Regulatory, Planning and Assessment.MBisson/GMansfield  
Reference: SD2020/0006  
Phone: 02 4974 2000

5 July 2021

**38 LOOKOUT ROAD, NEW LAMBTON HEIGHTS - JOHN HUNTER HEALTH AND INNOVATION PRECINCT (SSD-9351535)**

CAD FILE NO.
N169770-SK04-P1.DWG

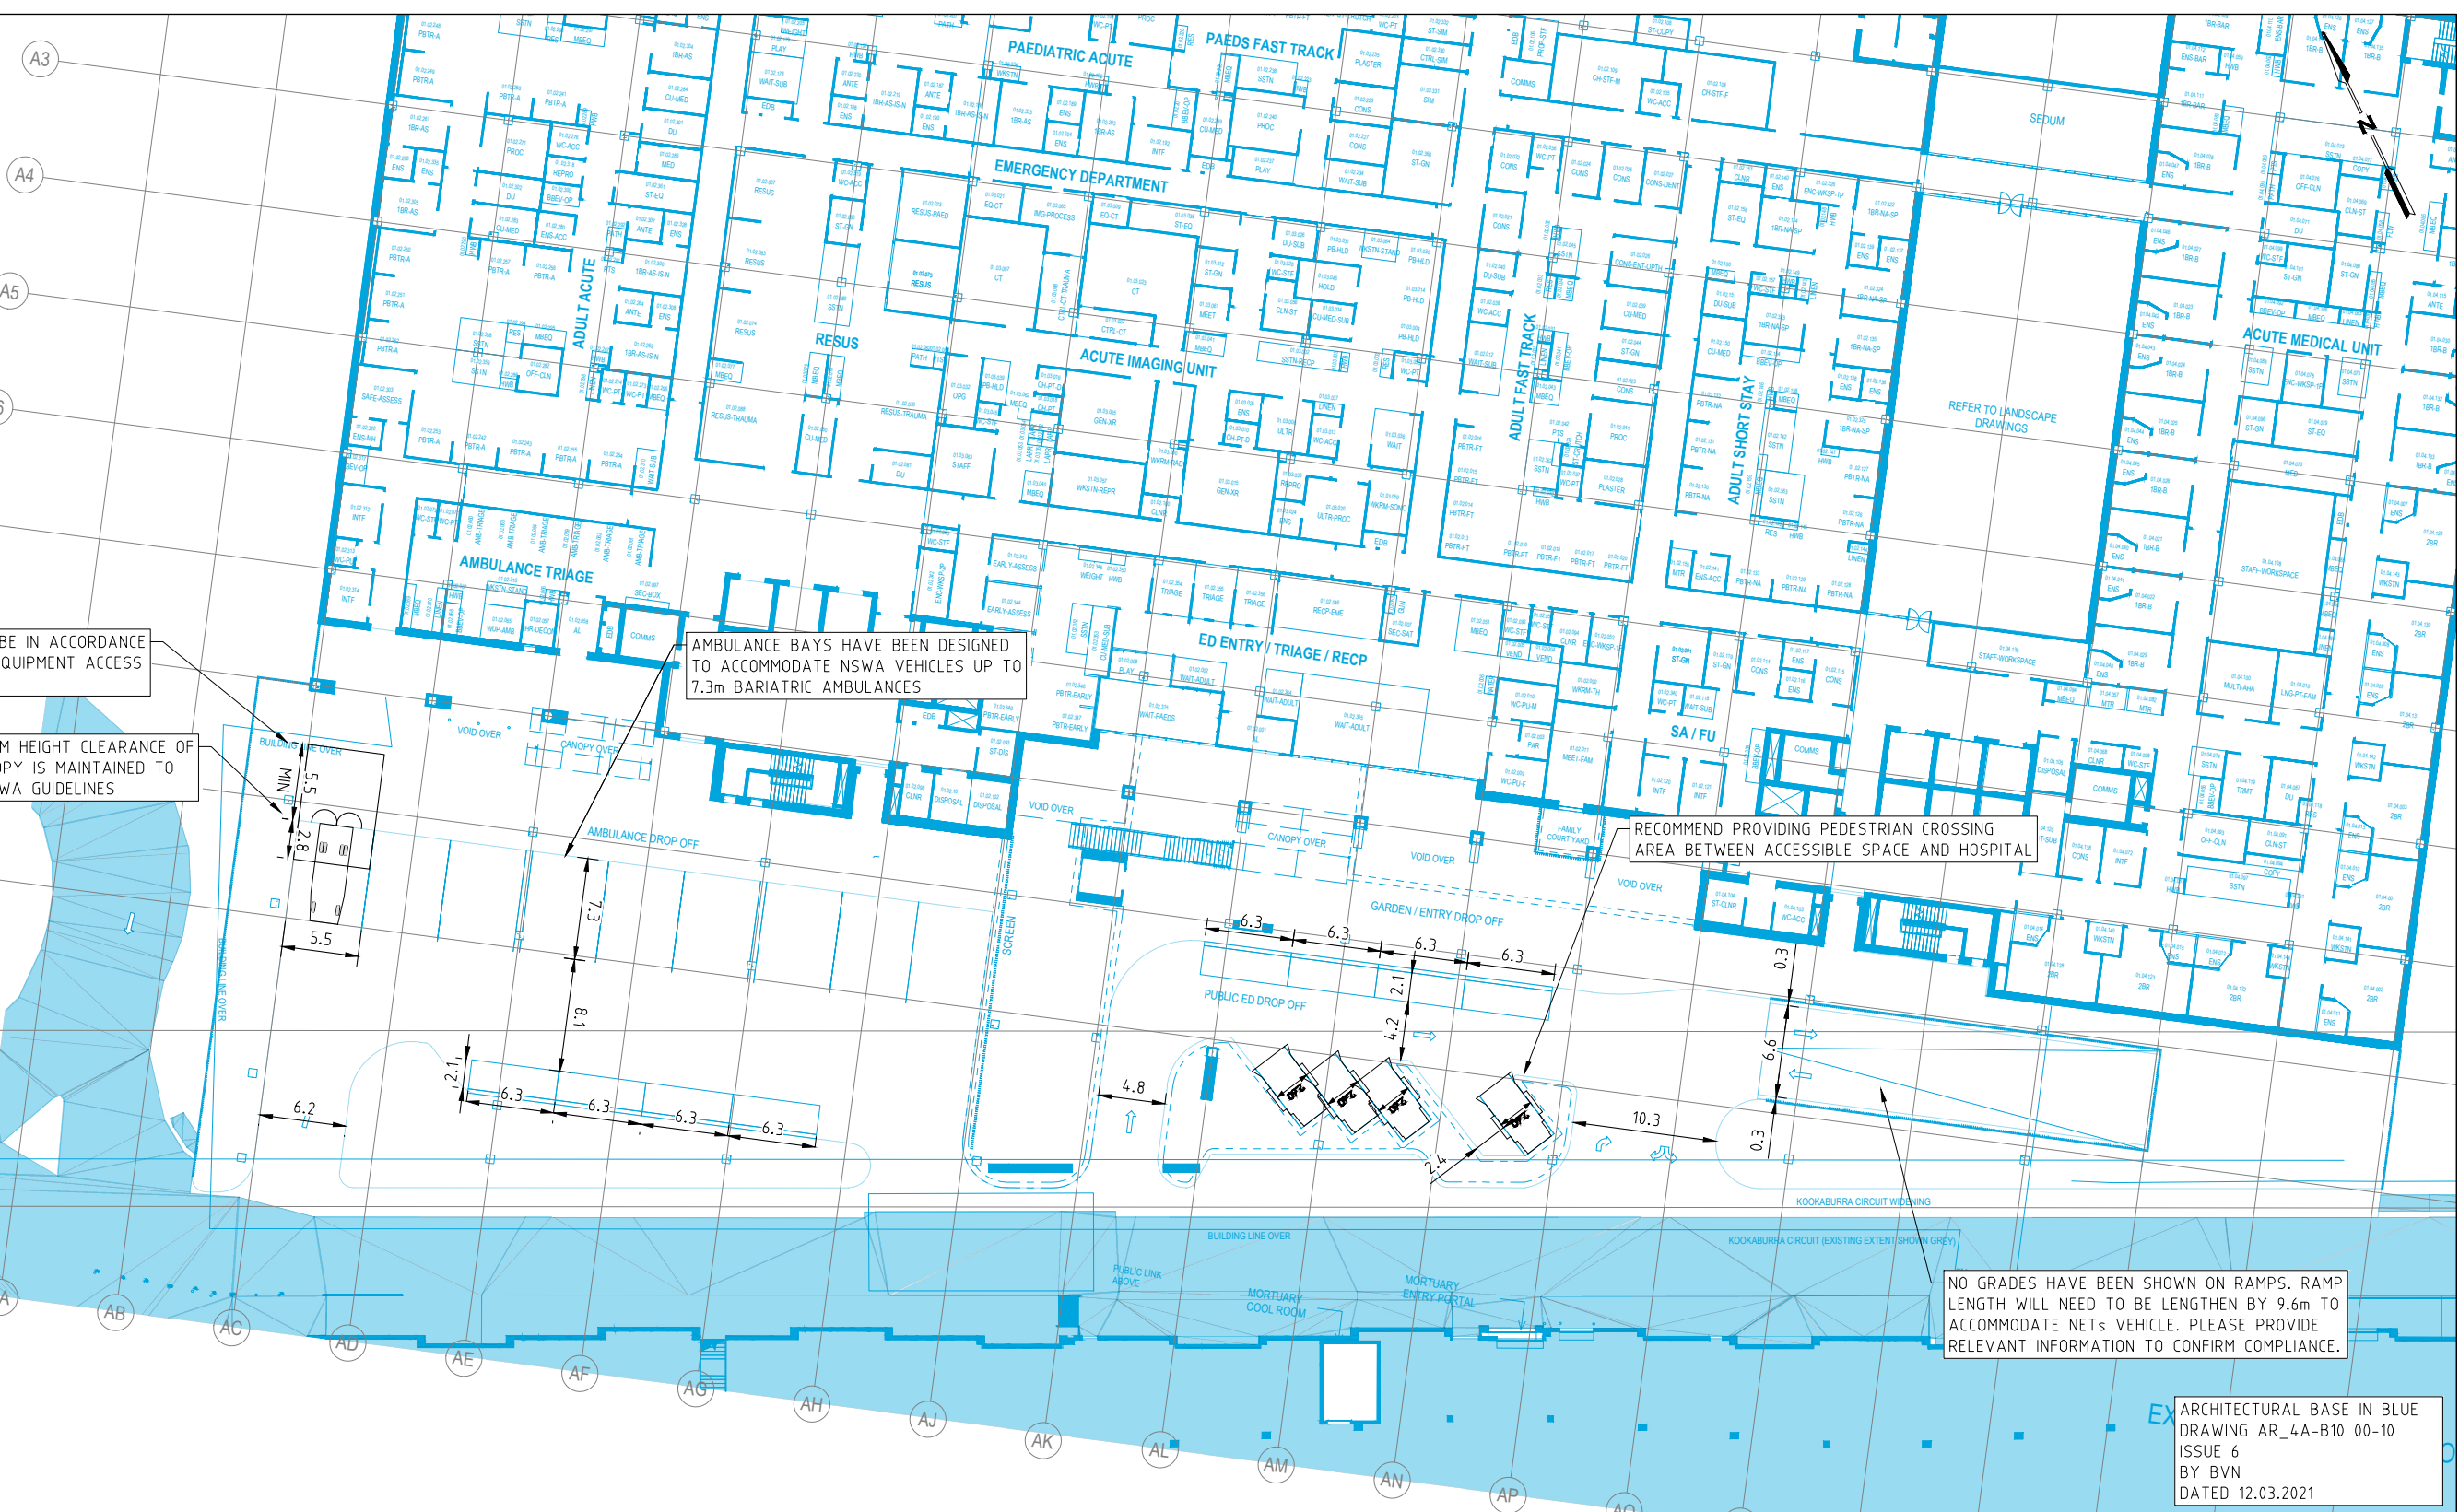
Furthermore, the vehicle Swept path plan prepared by GTA indicates that the northern section of Kookaburra Circuit between the proposed building and Jacaranda Drive allows for trucks to pass through the existing building underpass, thus appears to propose a two-way travel where it is currently one-way. This will likely result in additional works required within the road and the existing building, which has not been identified on plans. Height clearance at the underpass location would need to be confirmed.

Figure 14 - Stormwater Culvert locations and Catchments

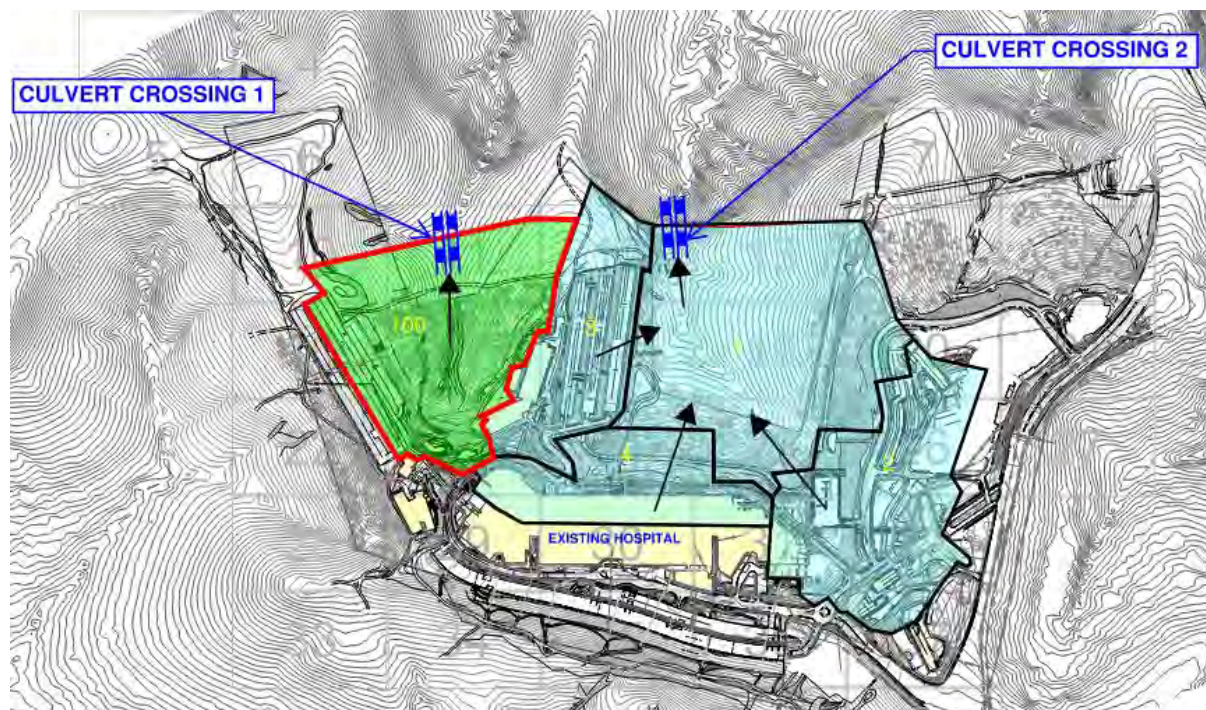
It is further recommended that the designs are amended to ensure culverts and pipes which discharge into downstream bushland include rock stabilised energy dissipator outlets, which apply natural channel design principles. The site specific, expert design and construction of these will protect upstream infrastructure from bed erosion risks. Unchecked, bed erosion can migrate upstream. Given the downstream contours (C100-DA-5) CN suggests rockwork is needed for respectively 20 and 40/50 metres to locations where the receiving waterway's longitudinal grade reduces.
